# Rezoning Transportation Analysis

Petition Number: 2020-156

General Location Identifier: Tax ID: 14125114

Date	Description
11-30-2020	First Review (KP)

ENGINEER: GTW  
 DRAWN BY: EBT  
 CHECKED BY: JLB  
 PROJECT #: 020.031  
 SHEET  
**RZ-1**  
 SHEET 1 OF 2

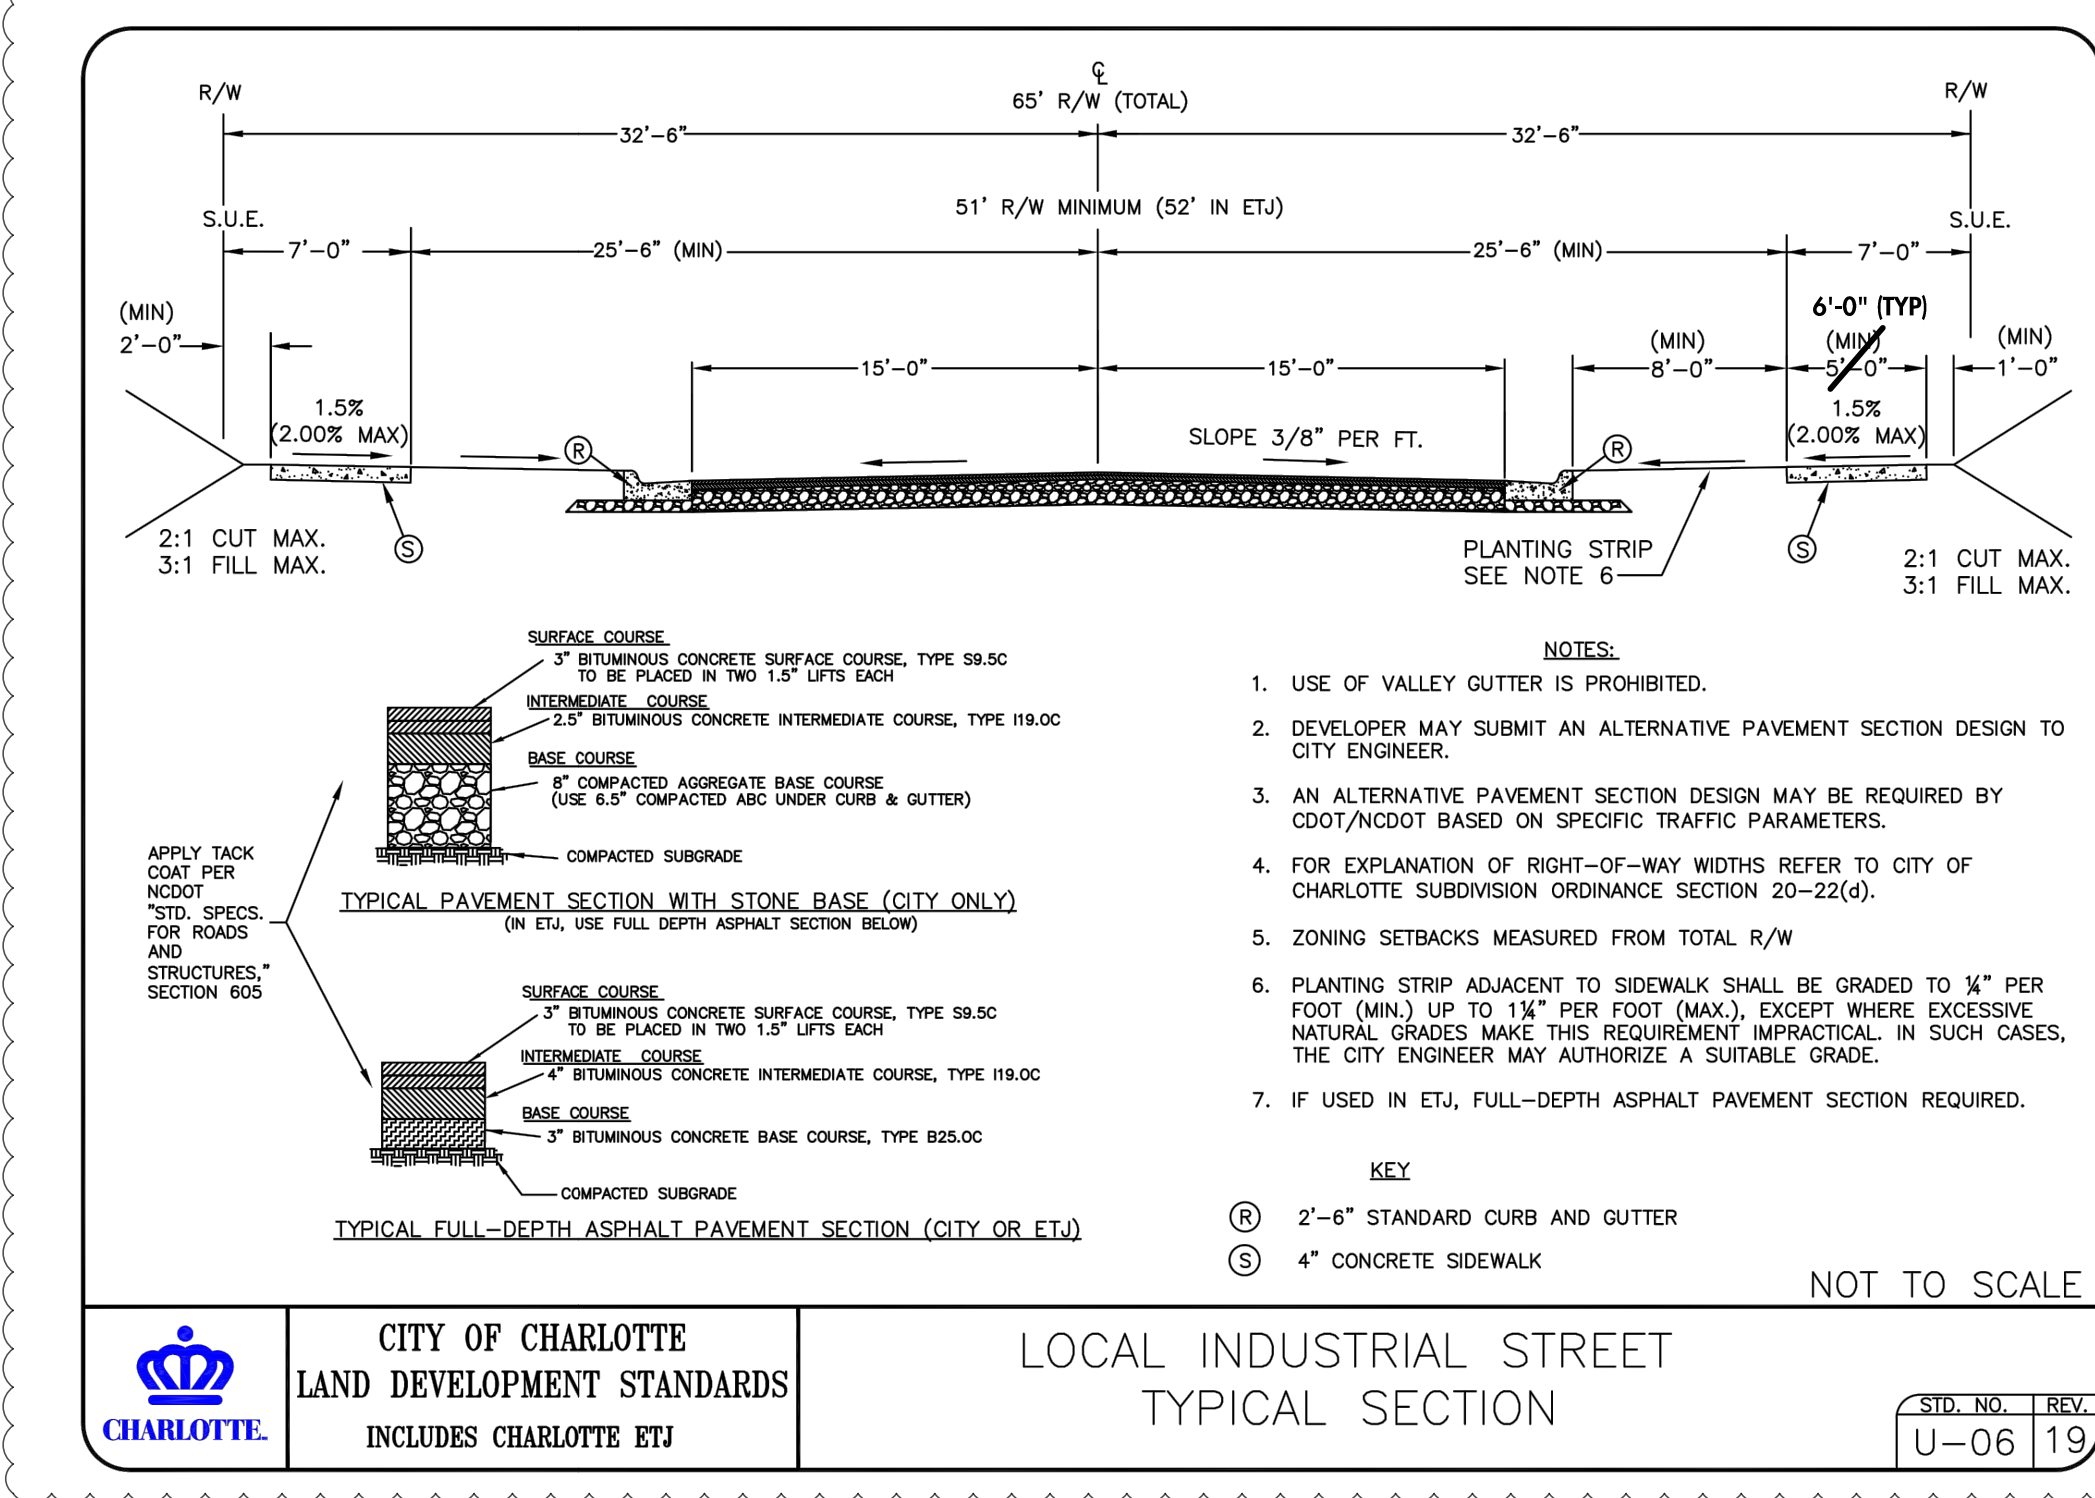
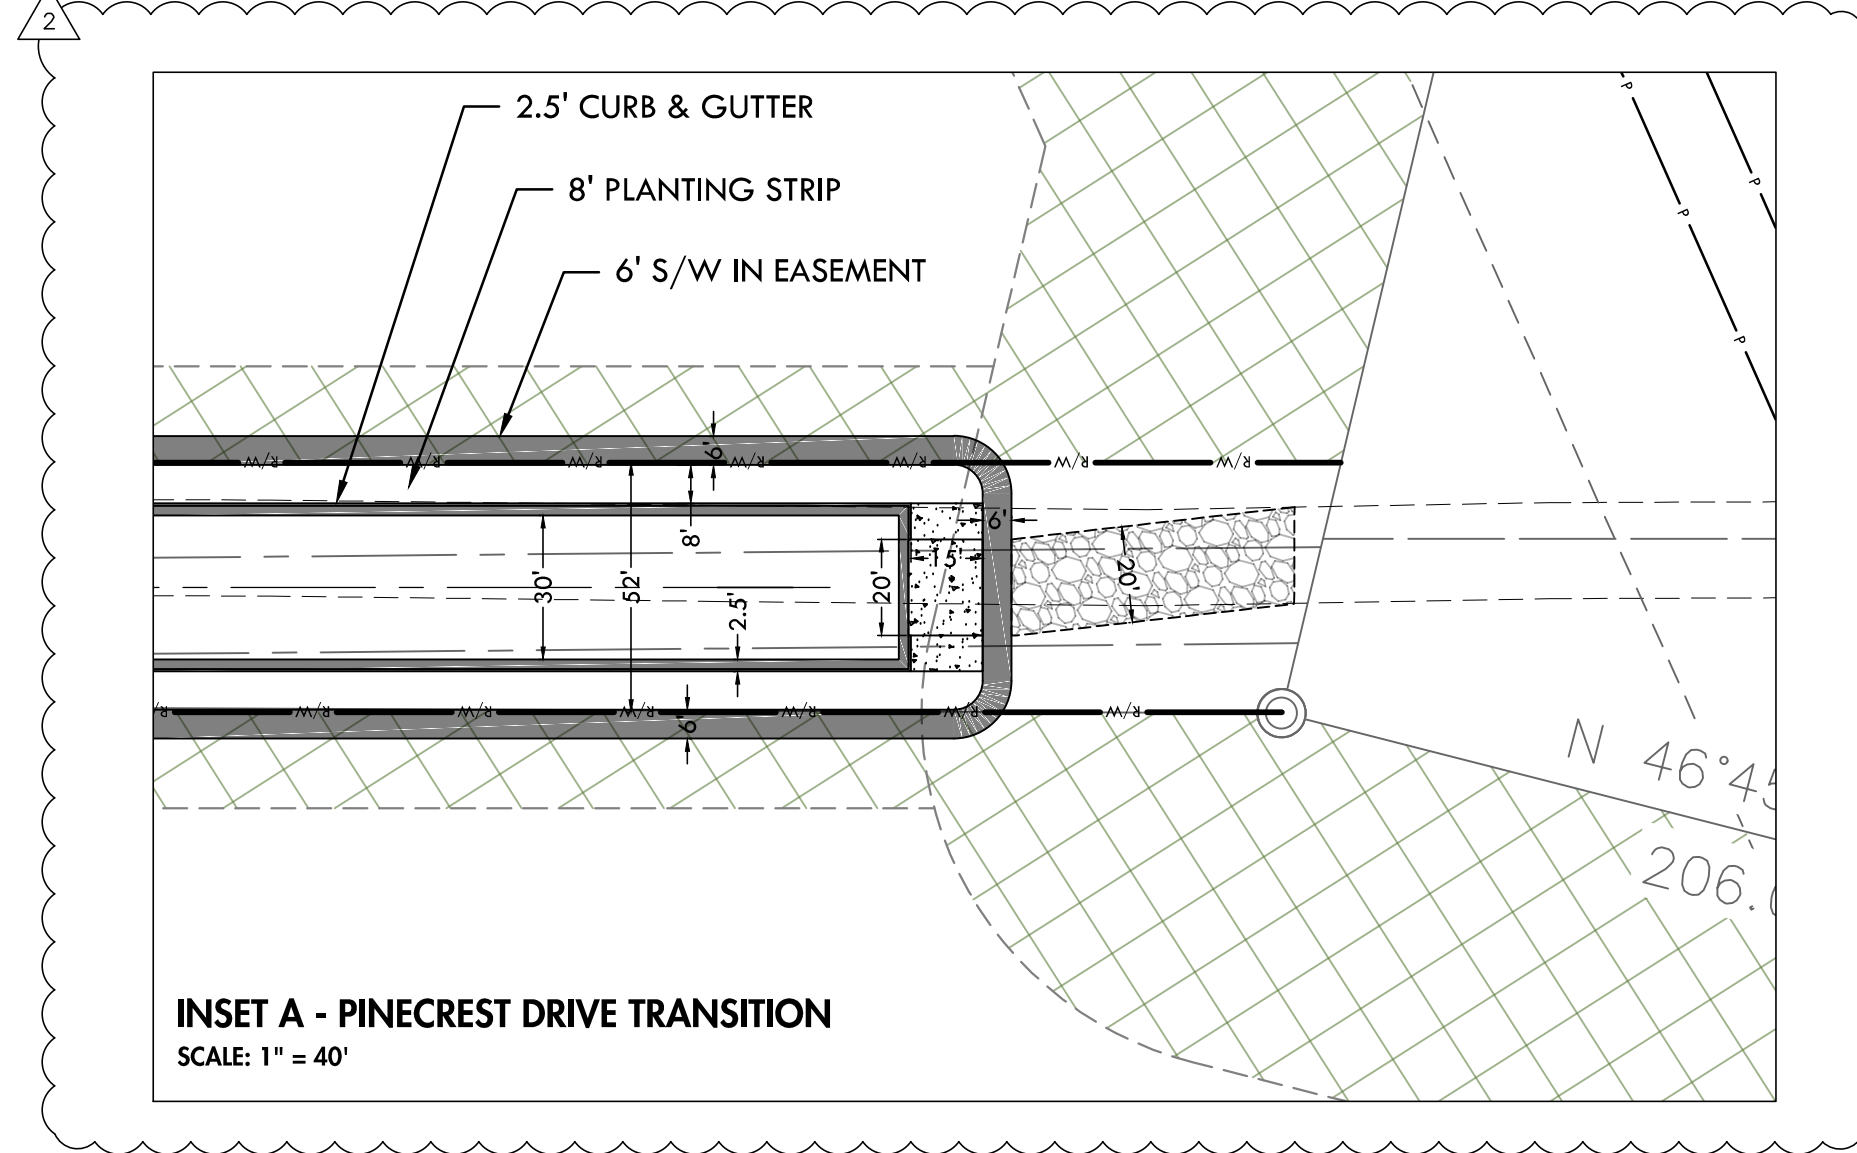
Shopton Road: The curb line will be located 27-feet from the road centerline to back of curb. Label and dimension the curb line from the road centerline.

3. Revise site plan and conditional note(s) to dedicate 43-feet of right-of-way, along the site's Shopton Road frontage, from the road centerline. Label and dimension the right-of-way from the road centerline.

4. Revise site plan and conditional note(s) to commit to construct an 8-foot planting strip, and 6-foot sidewalk on Shopton Road, per City Ordinances (Ch. 19/20). The site plan shall label and dimension both items from the back of curb and gutter and road centerline.

5. Revise site plan and conditional note(s) to commit to construct a 5-foot bike lane with a 3-foot buffer along the site's Shopton Road frontage to meet the City of Charlotte BIKES Policy and add to the infrastructure network in the area.

6. Continue coordinating on internal street network, including potential Shopton Road Extension CTP alignment, with CDOT. Further comments may be added once alignment(s) and cross section(s) have been determined.
